Our Ref: 2026/101783

Council Comments - SSD-73688210 - Queenwood School Sporting Facilities - 1100 Oxford Falls Road, Oxford Falls.

Appendix 1 Northern Beaches Council Submission - Detailed Supplementary Comments - SSD-73688210 - Queenwood School Sporting Facilities - 1100 Oxford Falls Road, Oxford Falls

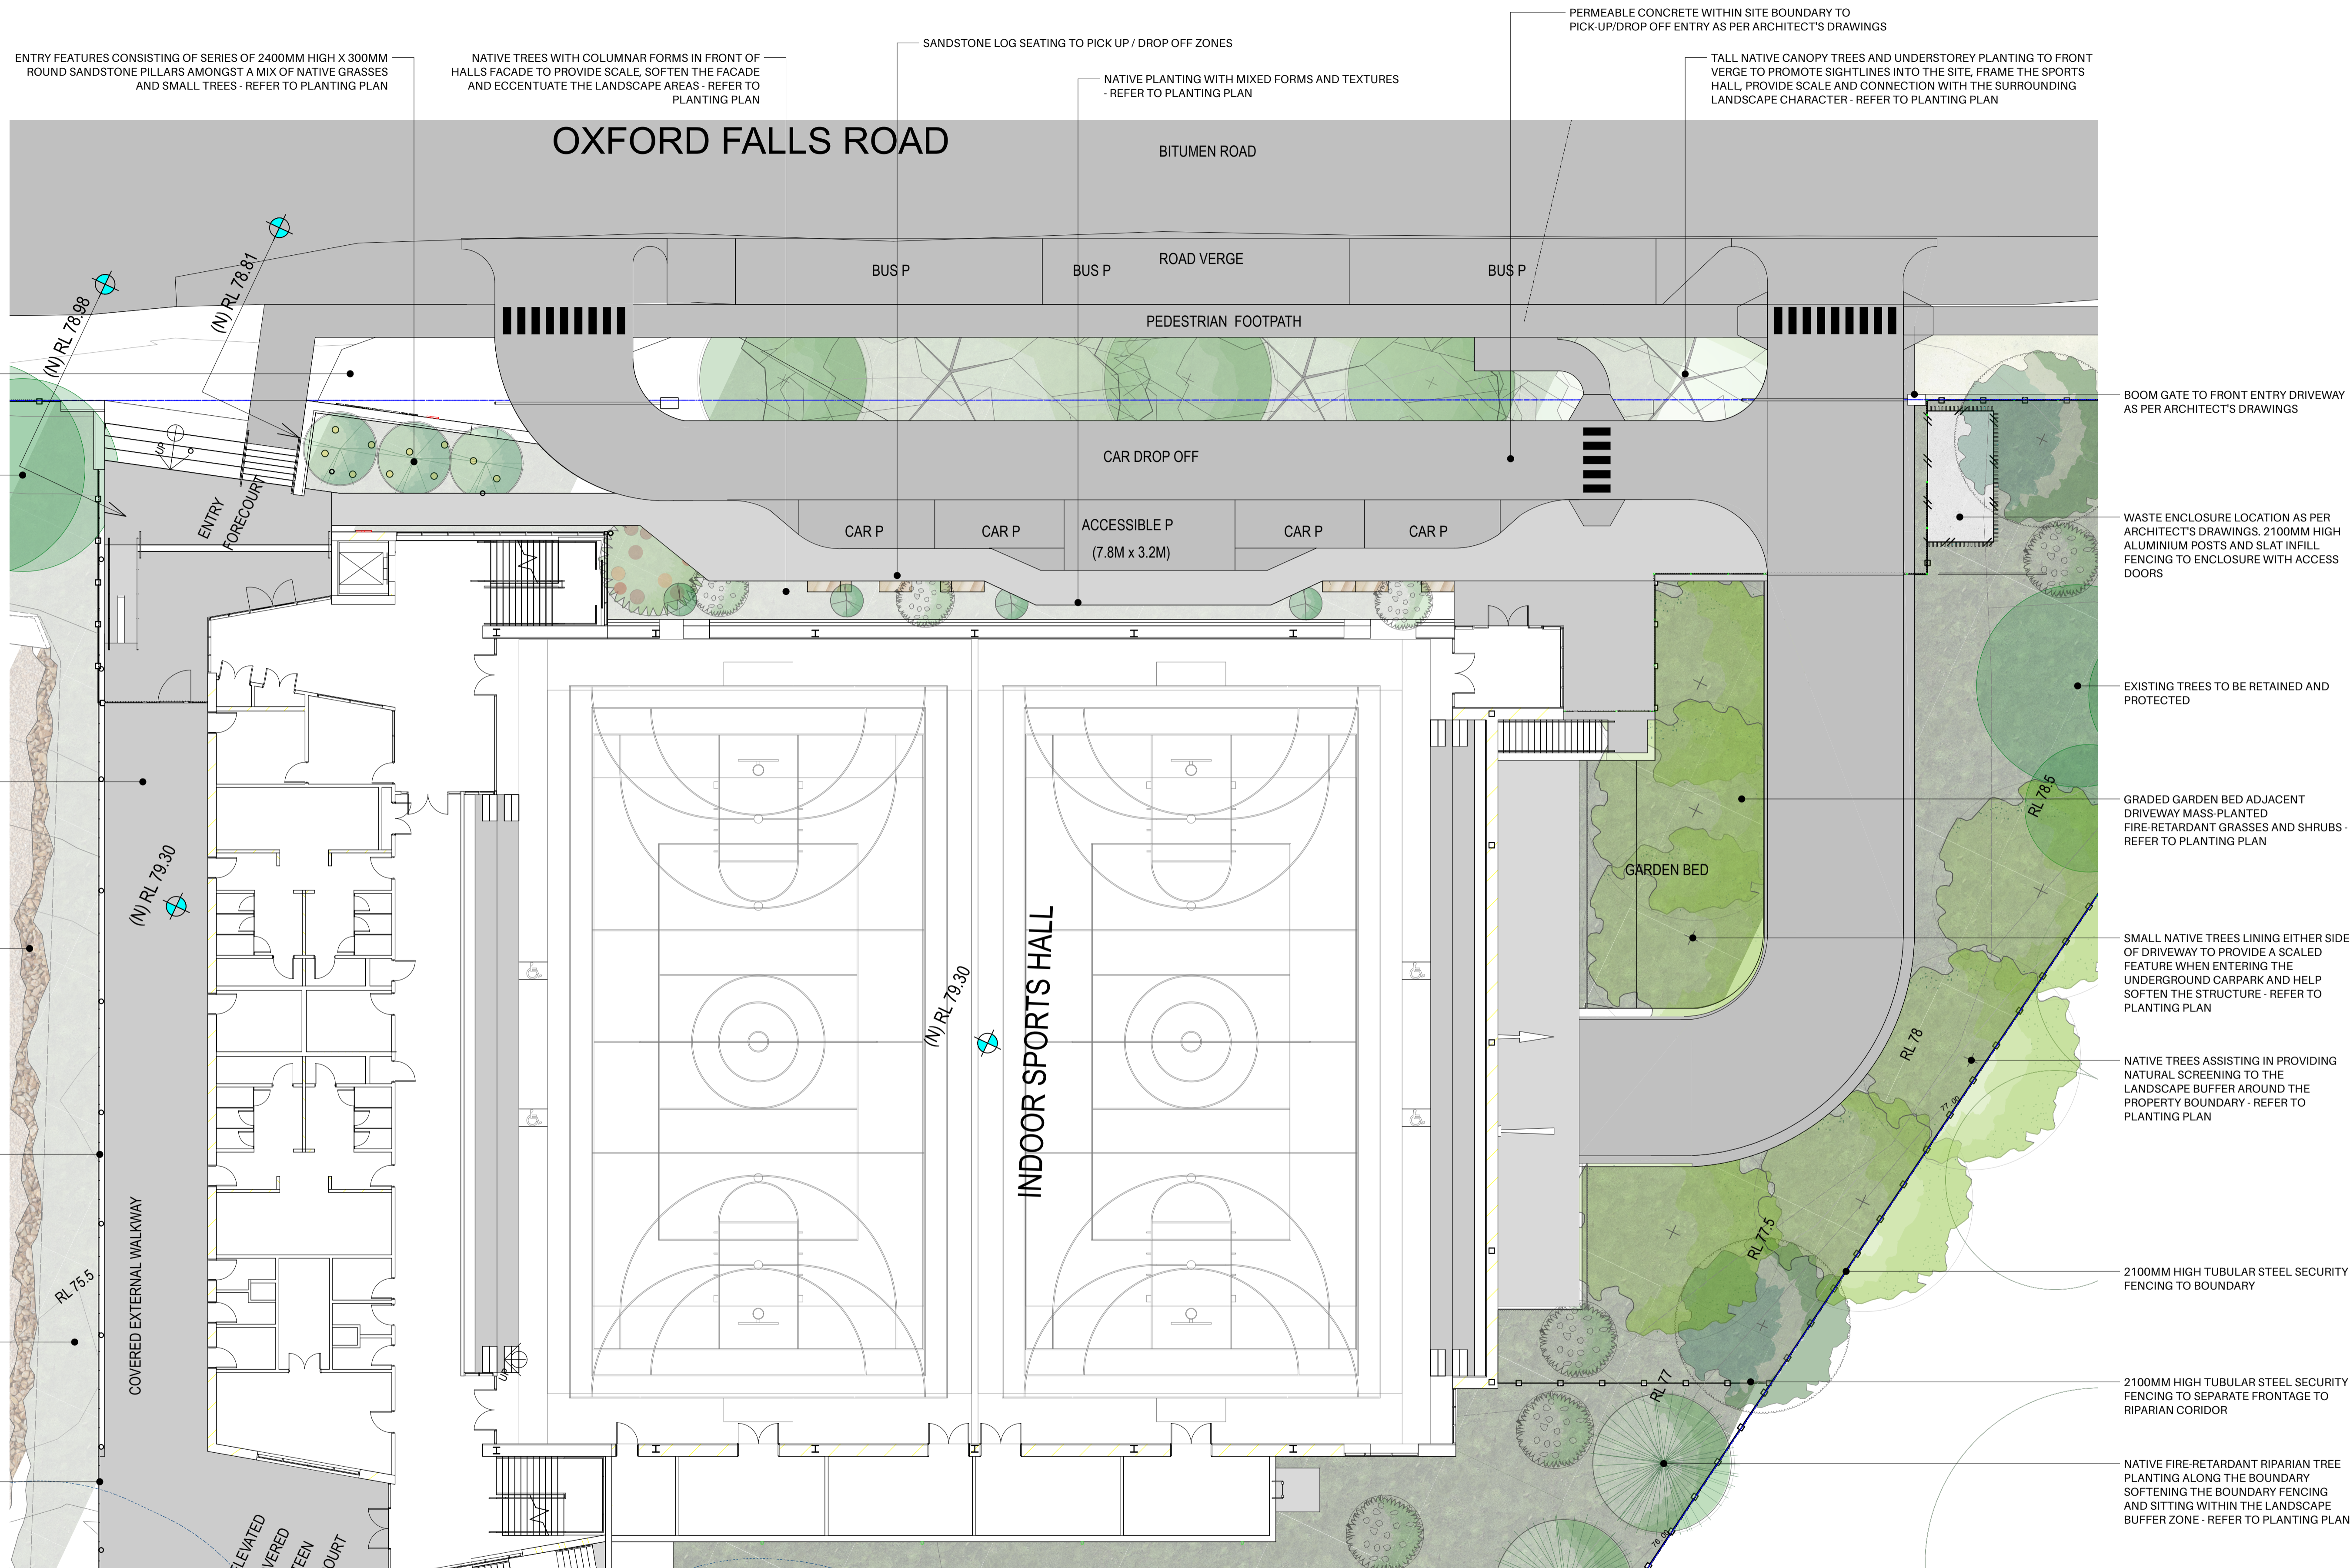
- Outdoor sportsfield
 - Recommend taller locally native canopy tree planting, such as *Angophora costata* along the frontage to Dreadnought Road. Tree planting indicated is relatively sparse and low-medium height. Local native landscape character should be enhanced along the public interface via the use of locally native tree shrub and groundcovers. This will assist protect and enhancing the natural landscape and integrating the 'hard' elements of the proposal (walls, fences and sportsfield lighting poles)

- Tree planting in the Dreadnought Road road reserve should also be considered to extend the native landscape character beyond the limited width garden area.

- Western and Southern boundaries of the sportsfield are indicated to be planted with Lilly Pillys as a hedge. Whilst a wider planting area would be preferable to accommodate a more varied natural mix of species, the narrow garden bed indicated in the design (approximately 1.5m wide) could accommodate the Lilly Pillys indicated. However, see Heritage comments regarding landscaping adjoining the Heritage items.

1 INDOOR SPORTS HALL - OXFORD FALLS ROAD (EAST) ELEVATION
1:200

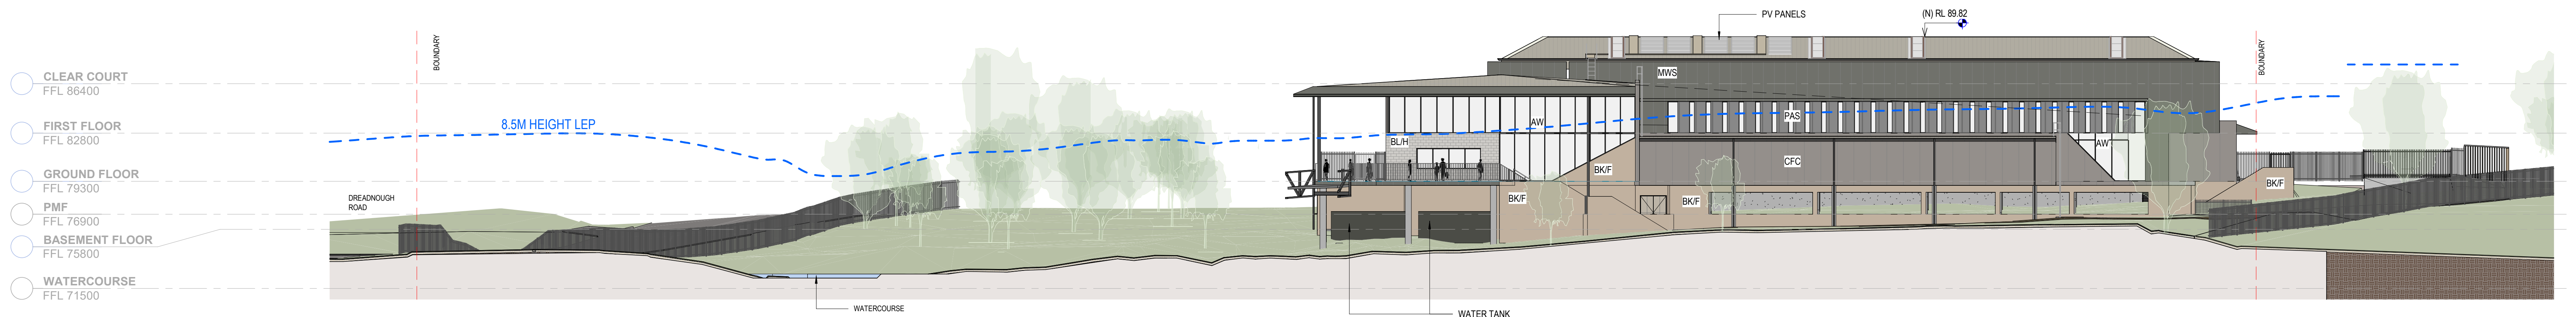
Floor level requirements are generally satisfied. However, the final design should ensure there is at least one step up from the ground level to the hall on its eastern side, so that overland flow does not enter directly into the hall. For Vulnerable uses such as schools, floor levels for the building and entry points for the basement car park are required to be at or above the PMF level or FPL, whichever is higher. Despite the fact that the report does not address freeboard in the overland flow flooding area (whereas Council does apply freeboard for overland flow flooding, generally reduced to 0.3m for 1% AEP flood depths less than 0.3m), it appears from Figures 18 and 20 that the floor levels would be above the FPL if freeboard had been applied. It should be noted that the FPL and PMF levels are quite close to each other on the eastern side of the hall, and that climate change has not been considered in the determination of the floor level. (The NSW Government's Flood Risk Management Manual requires consideration of climate change, and Council's draft DCP which is expected to go on public exhibition in 2026 would require inclusion of climate change scenario SSP3 plus freeboard. The report has estimated this would add about 0.2m to the 1% AEP level).

The final design should ensure there is at least one step up from the ground level to the hall on its eastern side, so that overland flow does not enter directly into the hall. The entry to the basement car park is above the PMF level, but it should also be ensured that any other entry points such as stairs and ventilation areas are also above the PMF level.
